# **Martin Place, Over Station Development, North Site**

## **Architectural Design Statement**

**22/04/22**

This Architectural Design Statement has been prepared as an accompanying document to the submission of a S4.55 Application. The following changes are proposed:

**SYDNEY METRO-MARTIN PLACE LEVEL 01 PLAN
GENERAL ARRANGEMENT**

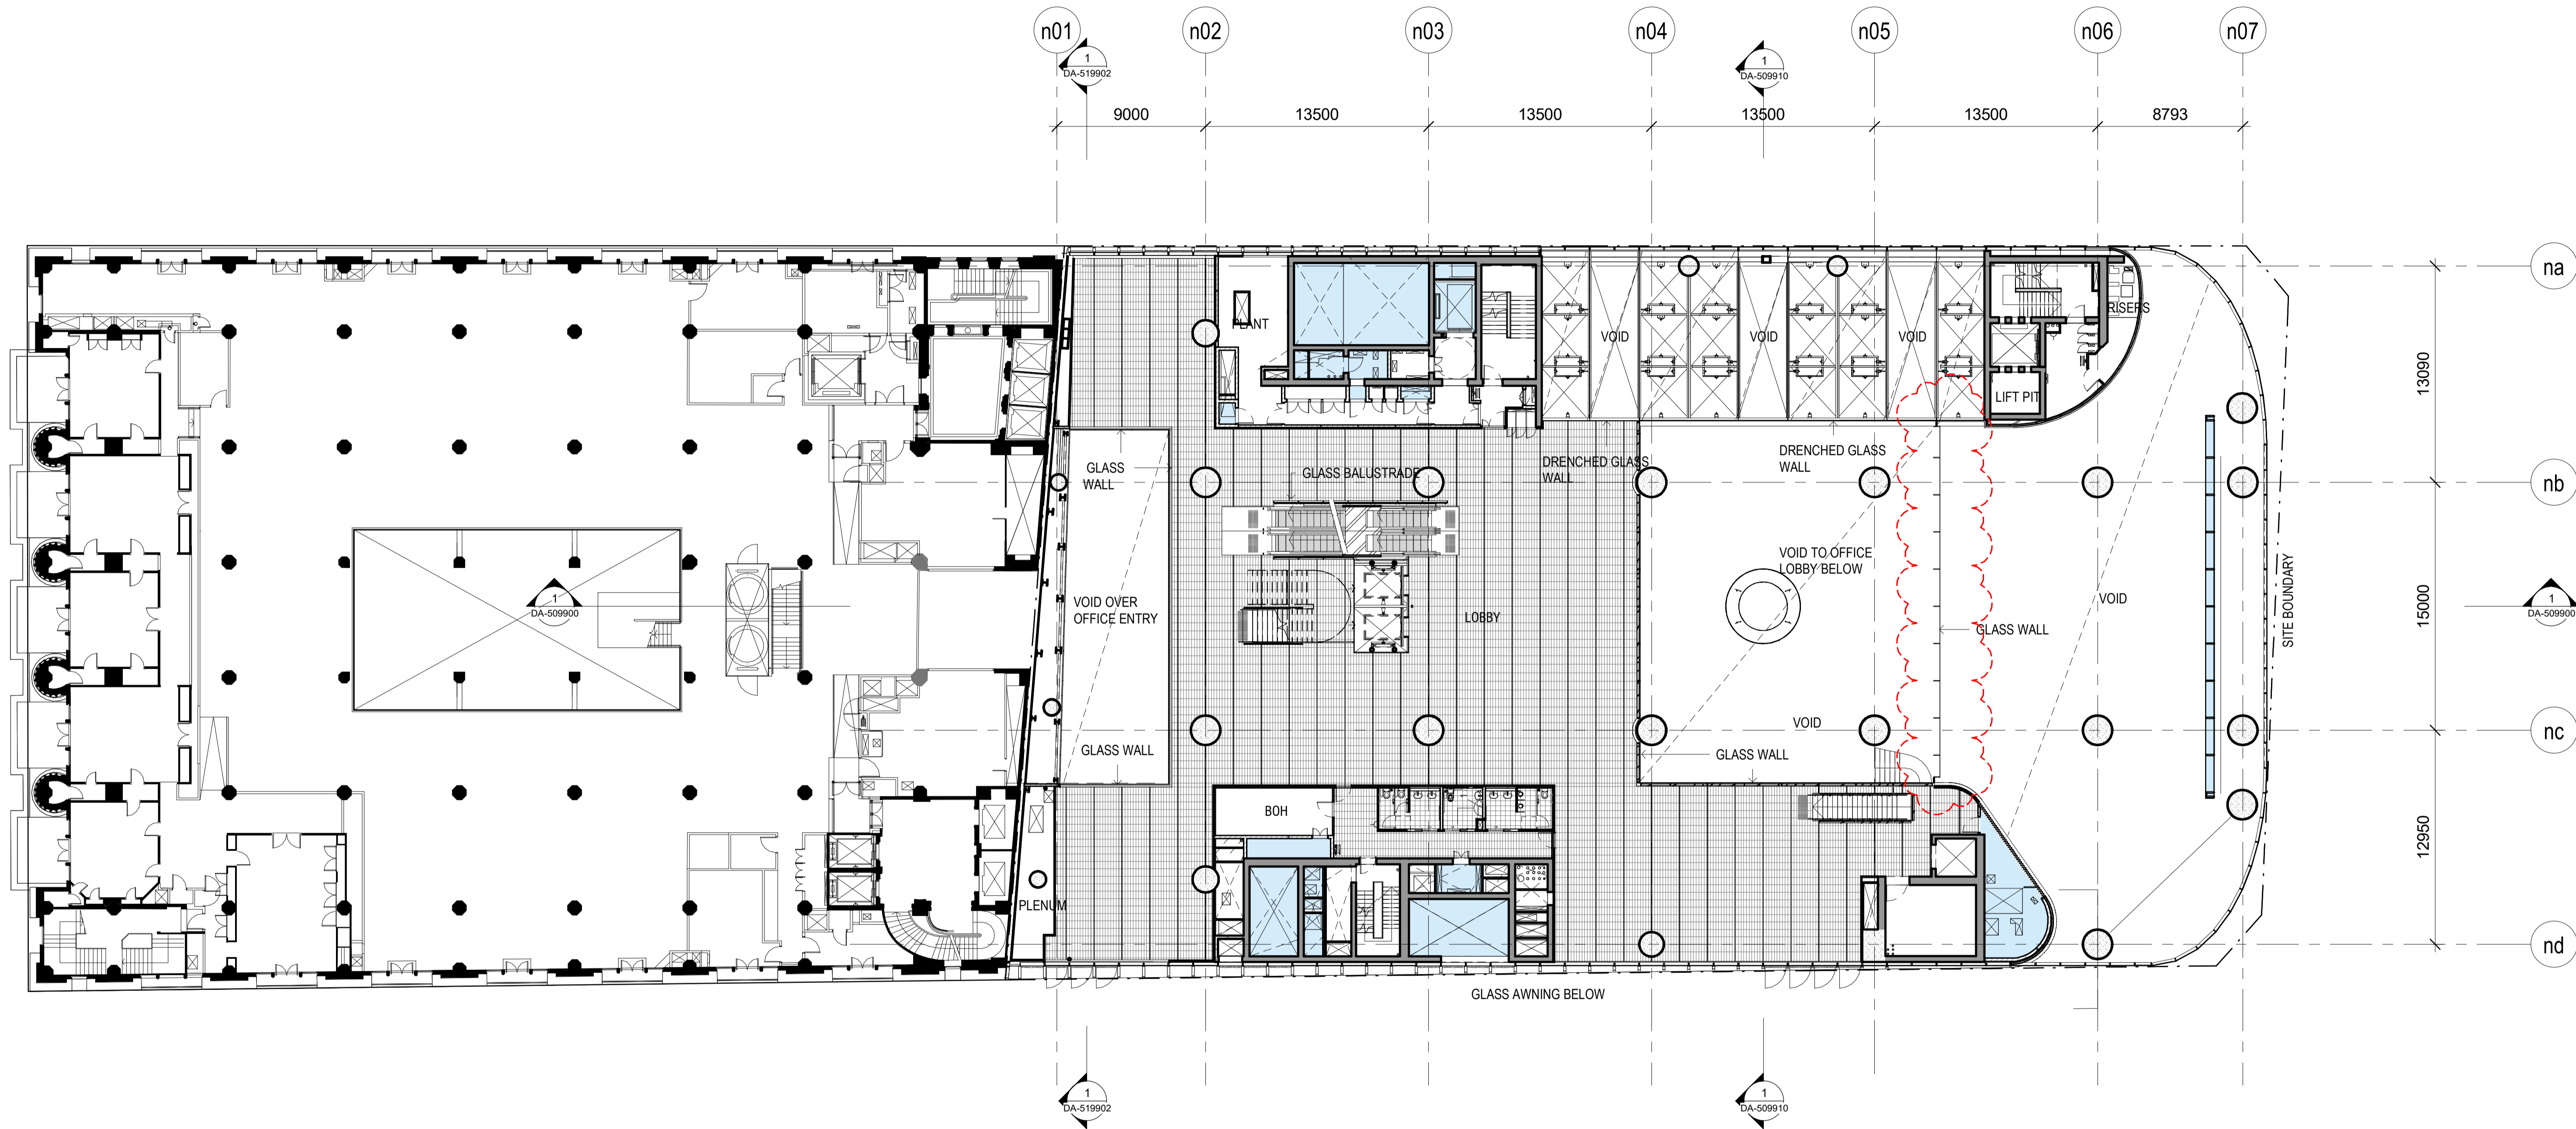
The approved design contains an elevated lobby with secure access into the glazed lift core. This revision comprises a reorientation of the revolving doors and an extension of the full height glazing to the northern end. Additional turnstiles and an interconnecting stair from Level 1 to Level 2 are also included.

This is a client initiated revision to increase the Level 1 lobby floor area and integrate Level 2 uses within the lobby enclosure.

Drawing Title
SYDNEY METRO-MARTIN PLACE LEVEL 05 PLAN GENERAL ARRANGEMENT
 Status
NORTH TOWER STAGE 5
 Drawing Number
CSWSMP-MAC-SMN-AT-DRG-DA-300500

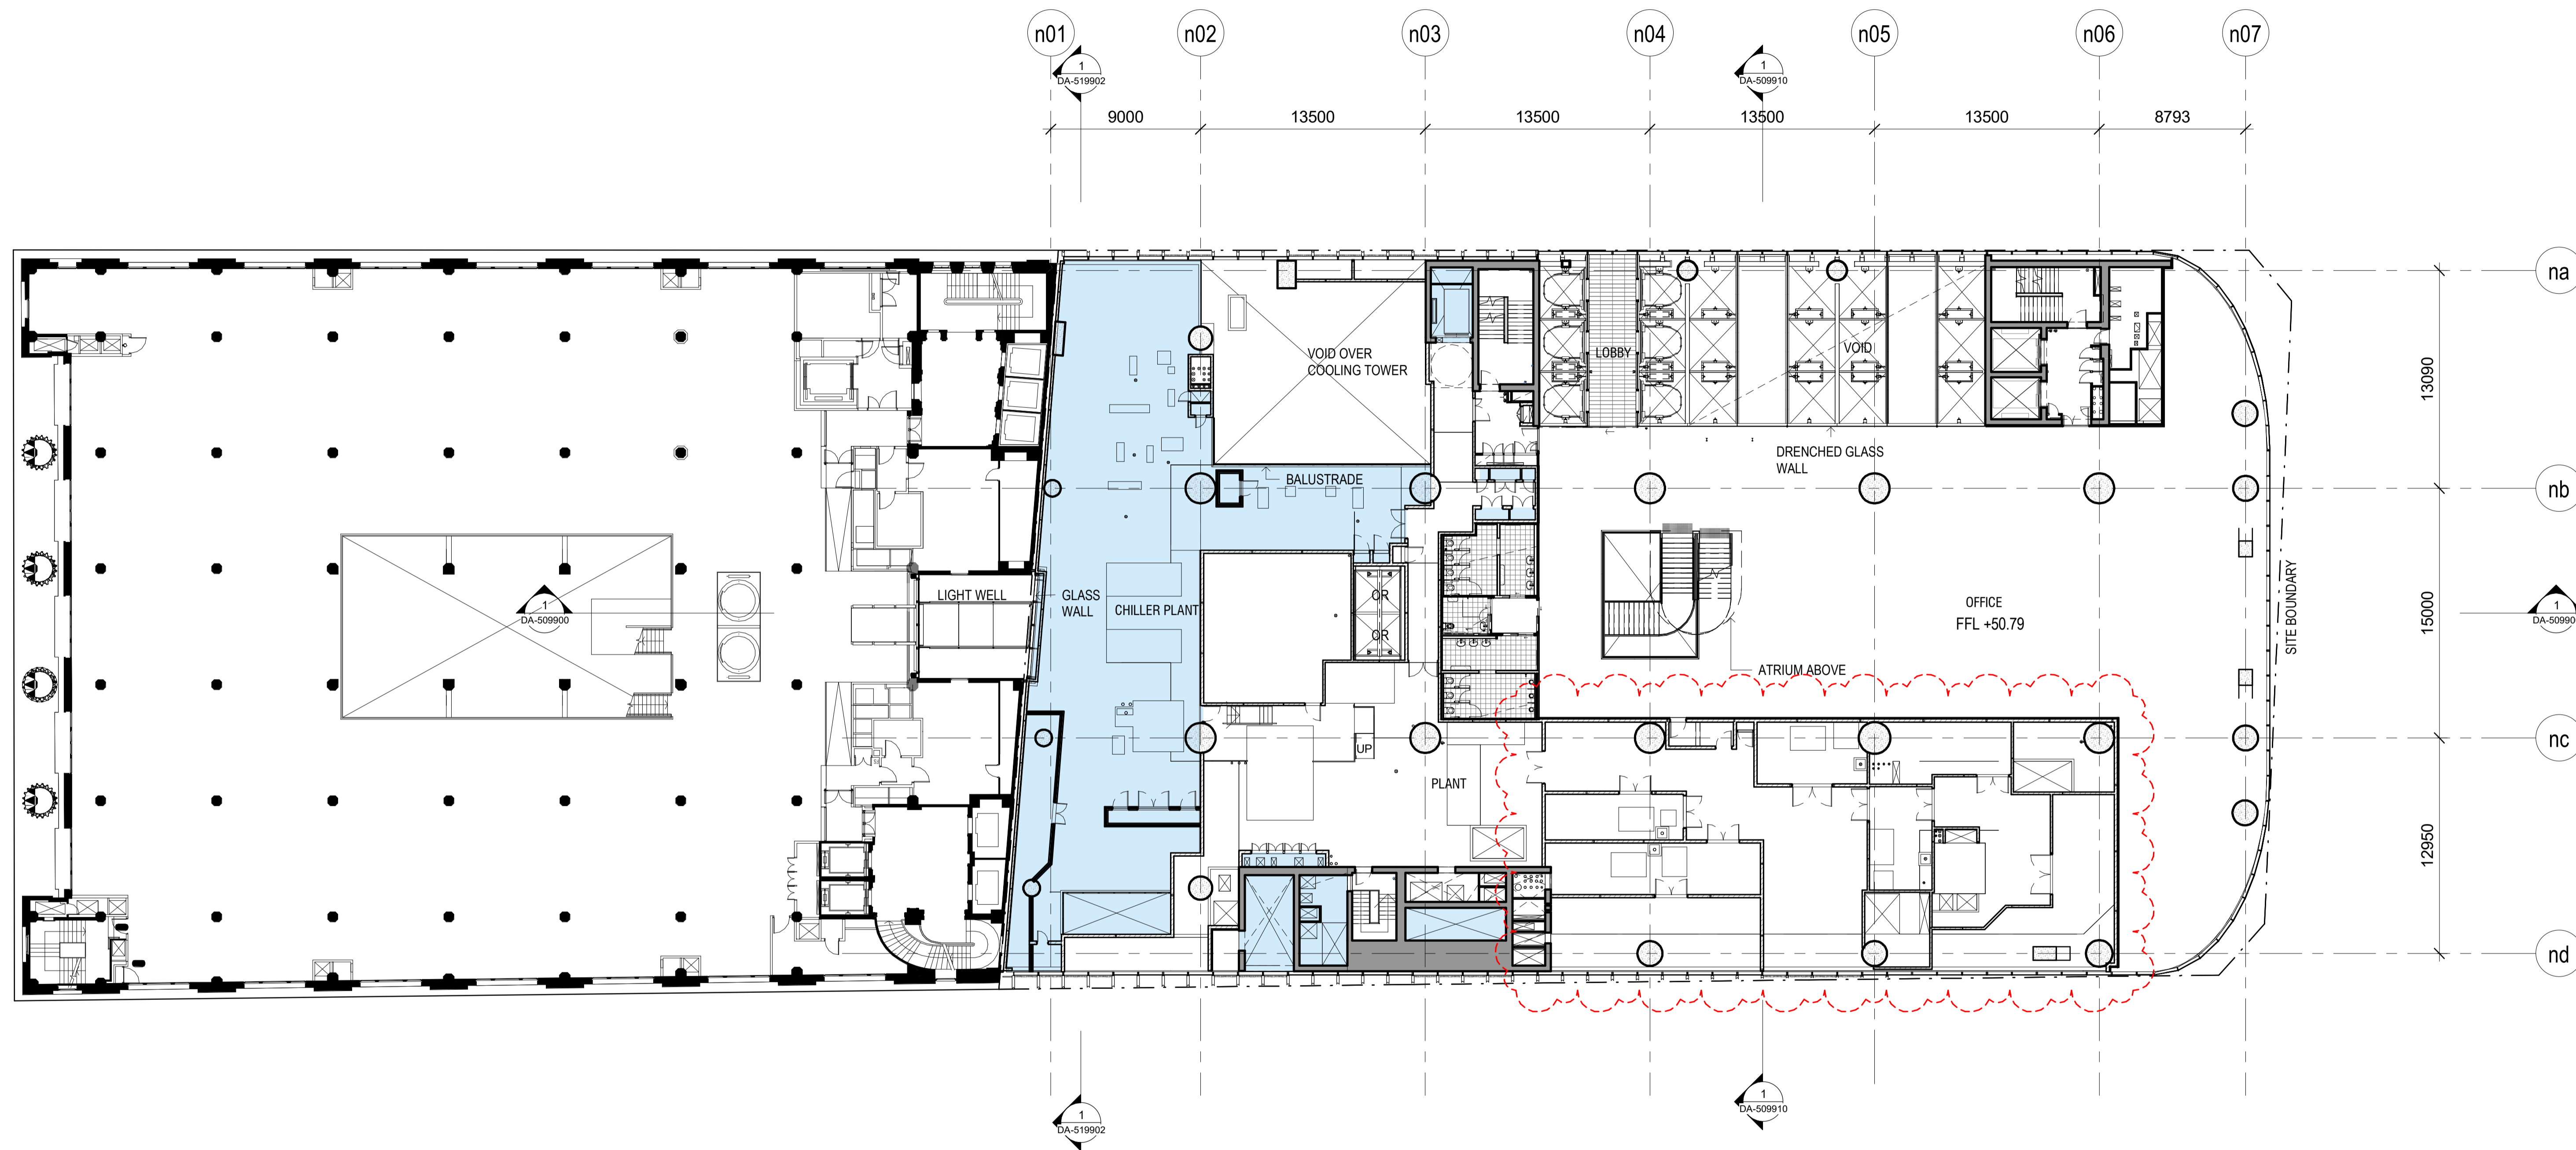
- Minor changes to cupboard doors and internal walls related to back of house amenities, goods lift lobbies and fire stair lobbies;
- Minor changes to the high rise fire stair setouts;
- Minor adjustments to the plant areas on Level 28, Lower Roof and Upper Roof; and
- Relocation of tenant plant previously approved on Level 5 to Level 6.

Revised plant elements

Drawing Title
SYDNEY METRO-MARTIN PLACE LEVEL 06 PLAN GENERAL ARRANGEMENT

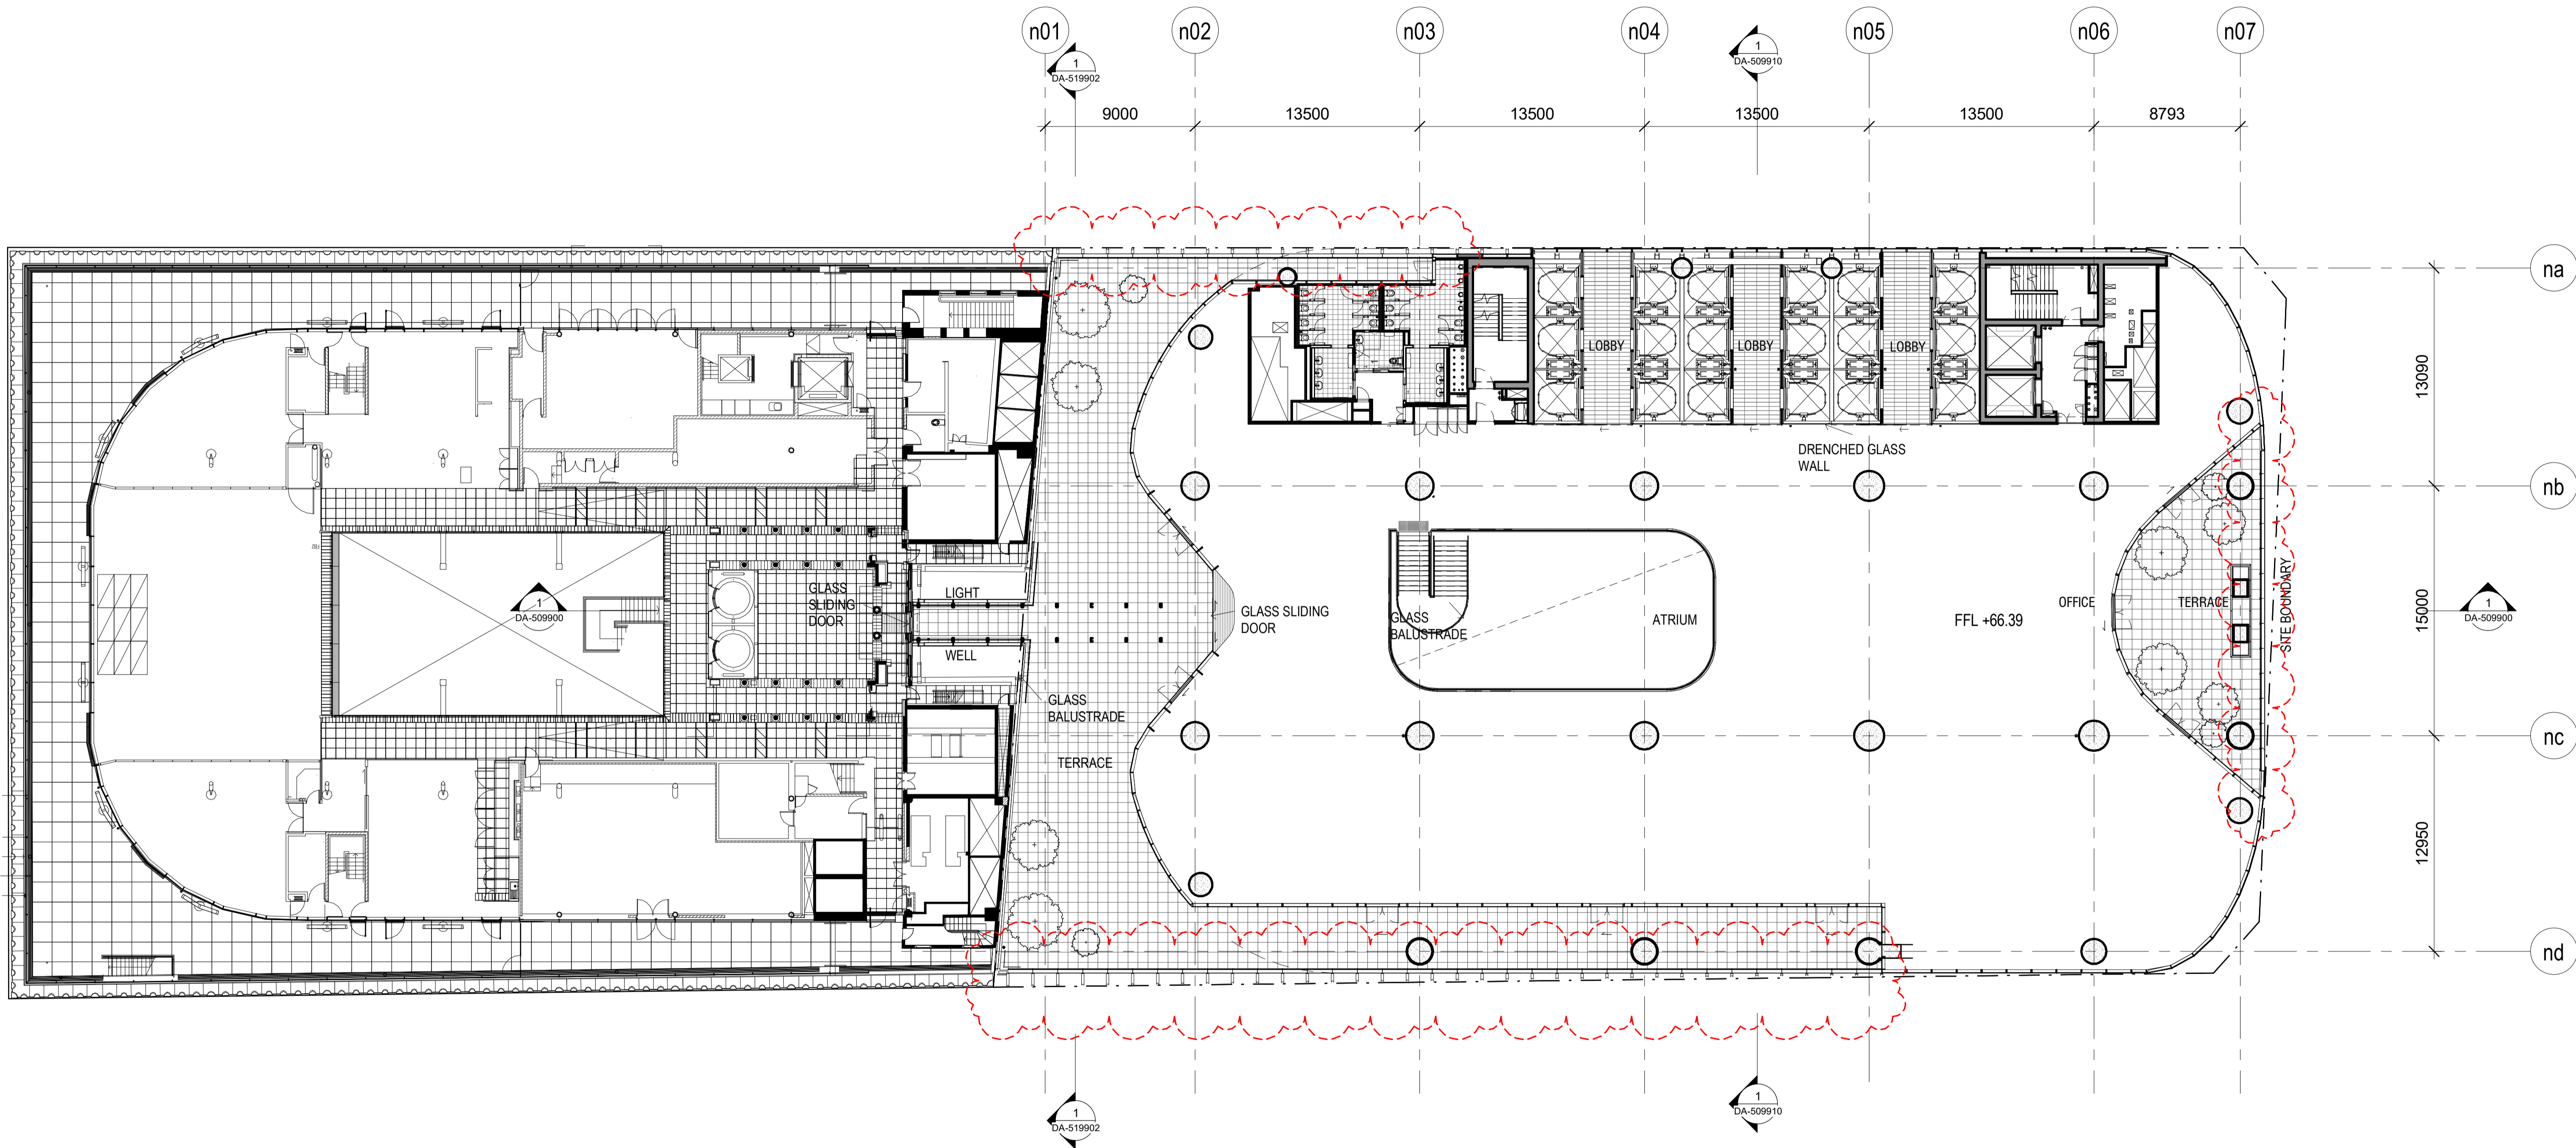
Plant elements relocated from Level 5
